SITE DEVELOPMENT PLAN  
**MONUMENT STEEL STRUCTURES**  
 SITE LANDSCAPE PLAN  
 18910 BASE CAMP ROAD  
 MONUMENT, COLORADO

# Landscaping\_v3-redline.pdf Markup Summary

SITE LANDSCAPE PLAN

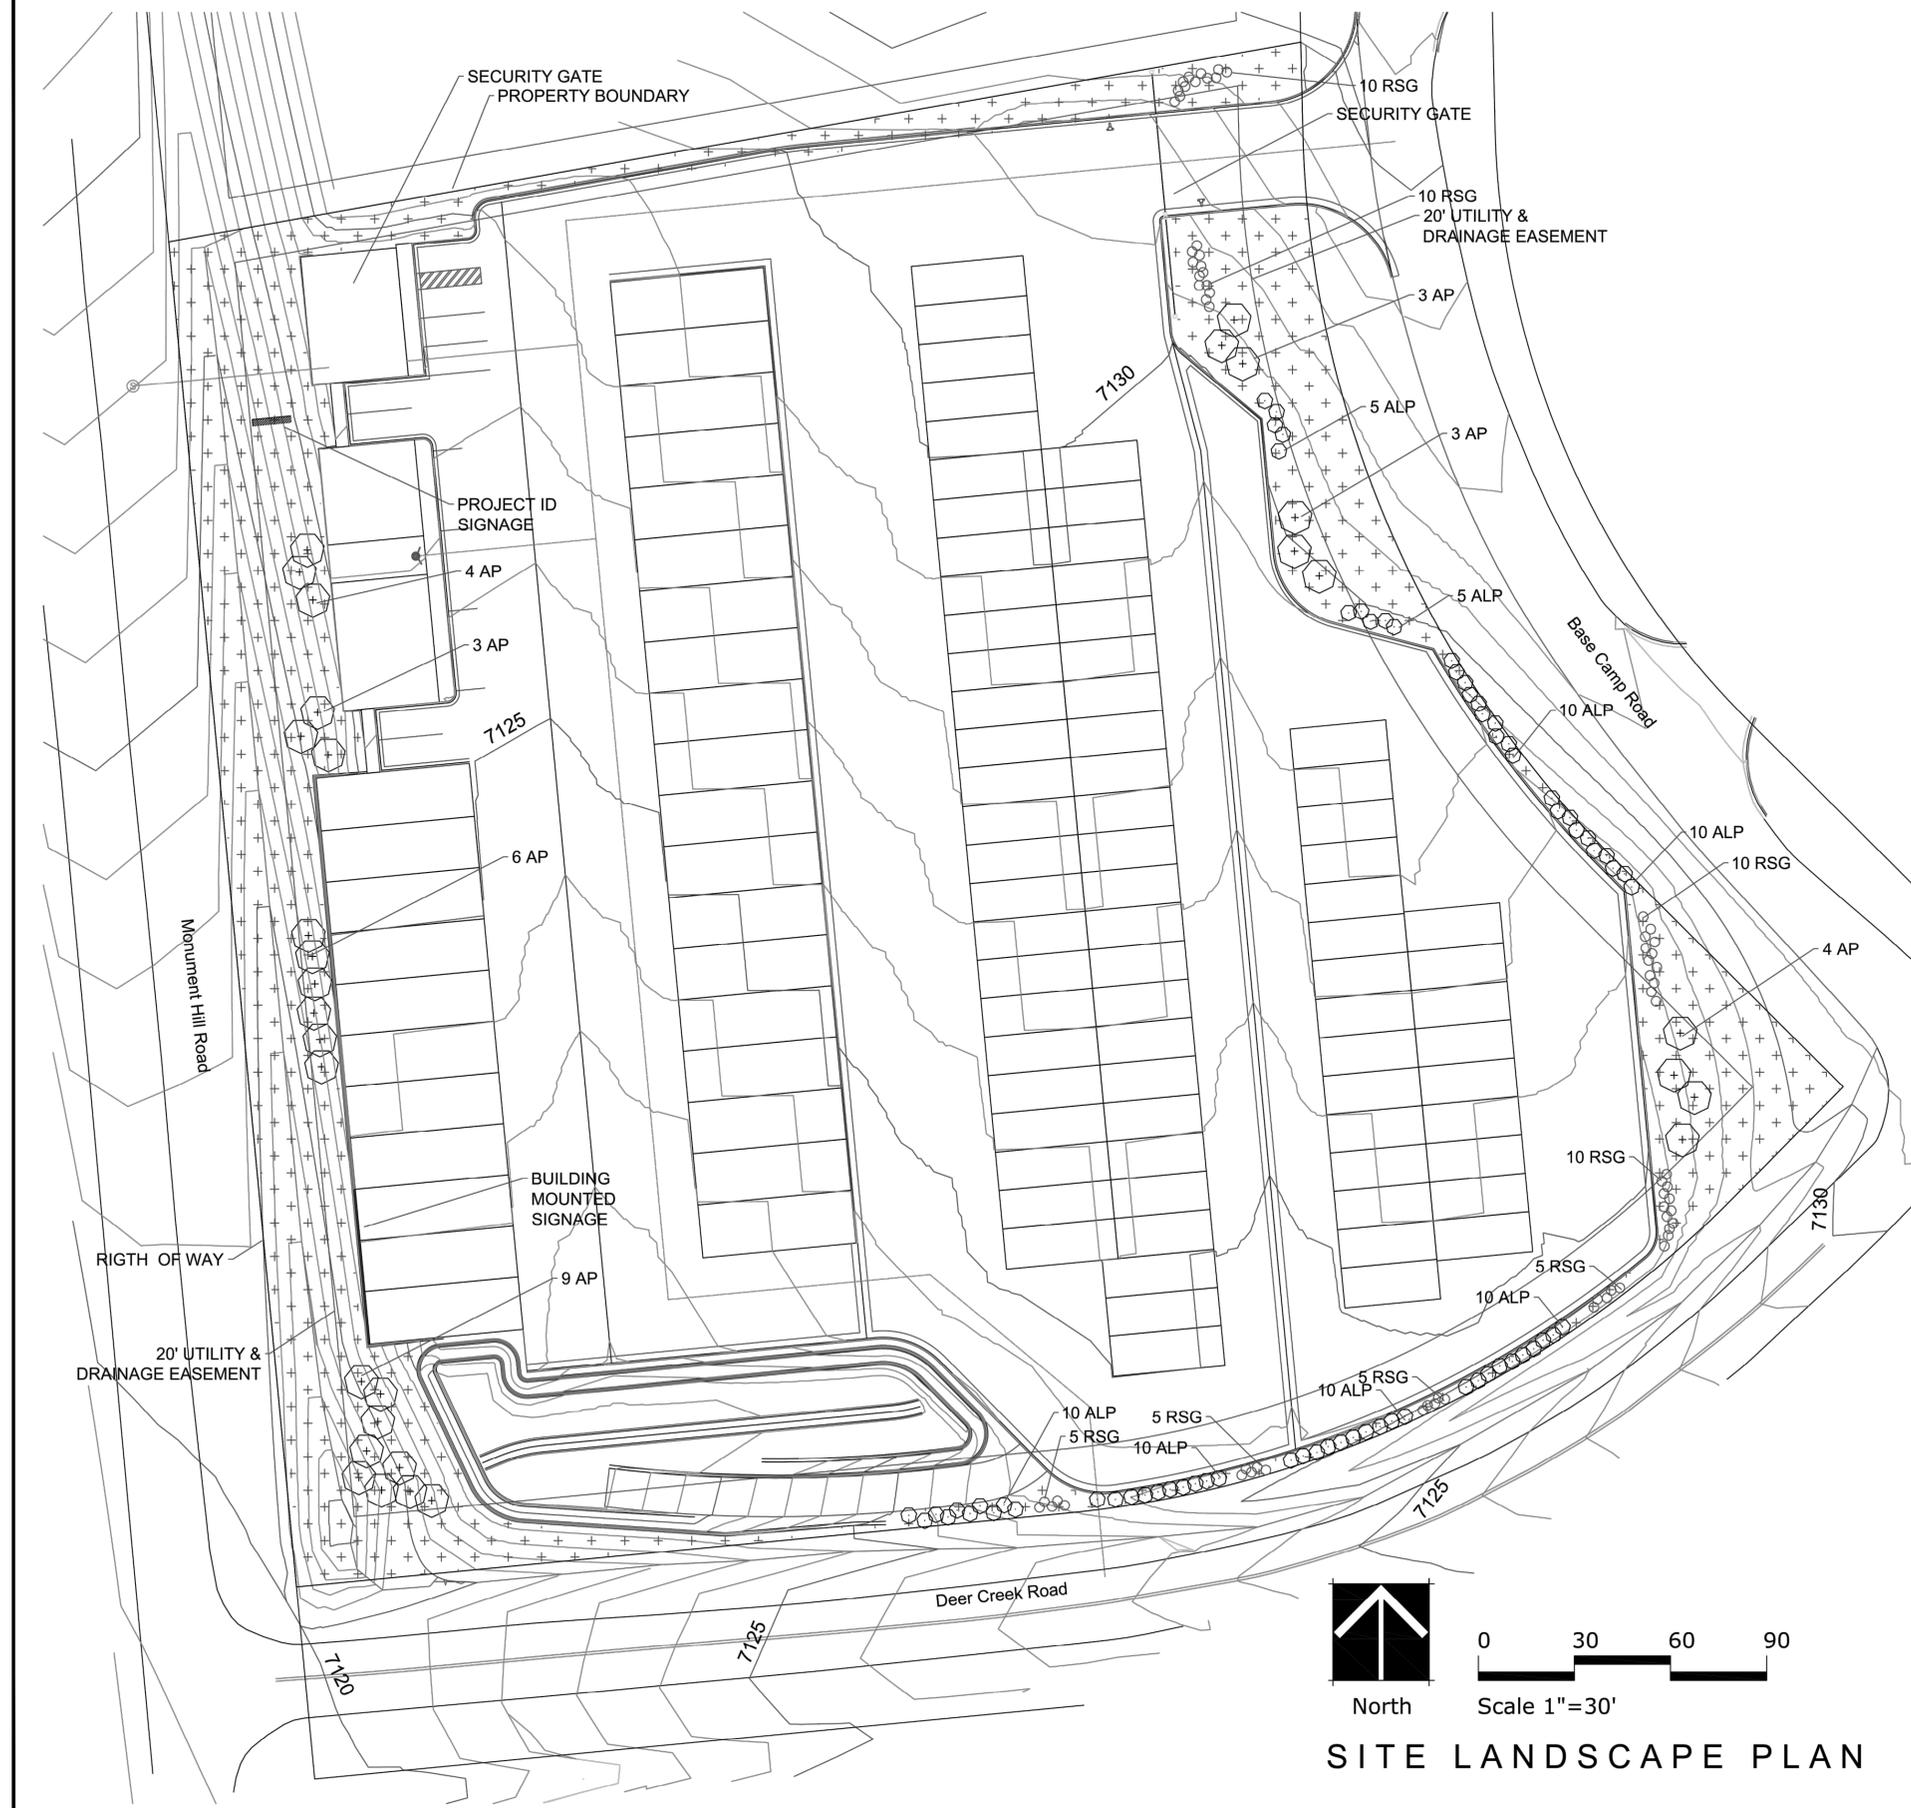
Where is the sign going?

Signage was put here on the sign plan.
